Recommendation Report for Planning Permission for Works or Extension to a Dwelling

REF NO: Y/66/20/HH

LOCATION: 4 Lambs Cottages
 Bilsham Road
 Yapton
 BN18 0JN

PROPOSAL: Single storey rear extension including demolition of existing extension.

Title: Proposed Elevations LA001_20
Scale: 1:100
Date: 06/20

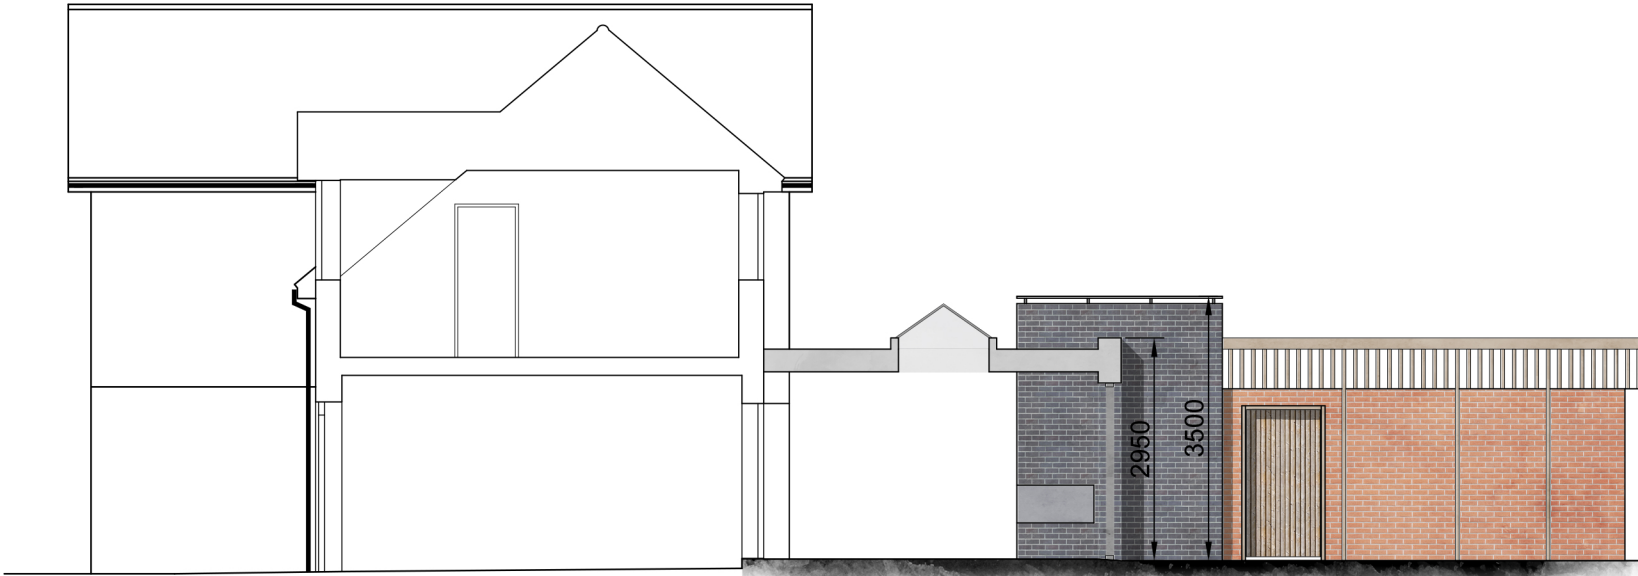
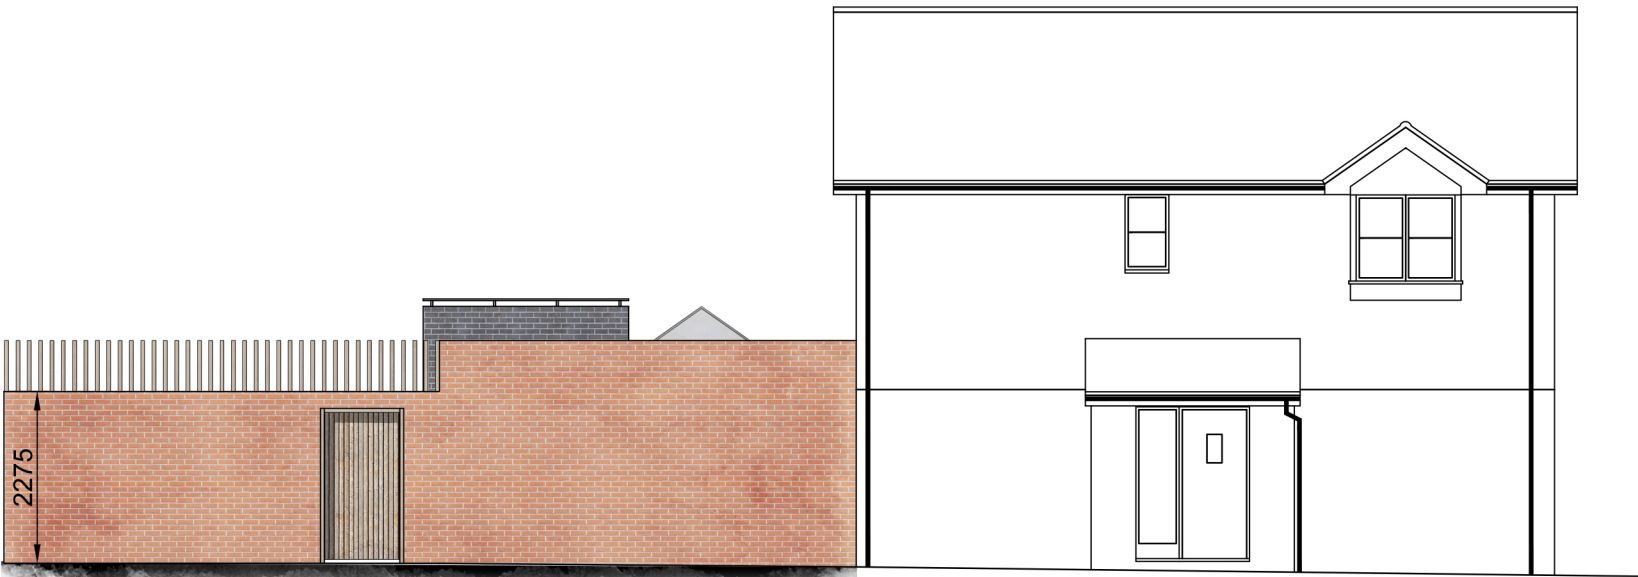
The extension is of relatively contemporary design featuring a black brick feature to the part of the extension and a timber brise-soleil to the north eastern elevation.

The extension will have a depth of between around 4.5m and 5.5m as it increases in depth to the north western boundary which fronts the road. However the wall of the addition to the south eastern side extends an additional 1.6m forming a surrounding/parapet wall and therefore the total depth of the wall along this elevation will be around 6.2m. The height of the extension will be 2.95m.

There will also be a larger brick feature wall which will have a maximum height of 3.5m. This however only forms a small part of the extension and is situated around 5.6m from the boundary fencing which is considered an acceptable distance from the boundary to the nearest neighbour and as such this element is not considered to appear adversely overbearing or overshadowing.

To the north western elevation there will also be a sun trap feature to a height of around 2.95m which is visible above the boundary wall fronting Bilsham Road however, with it an open structure and with no neighbours to this elevation, it is not considered to give rise to adverse impacts.
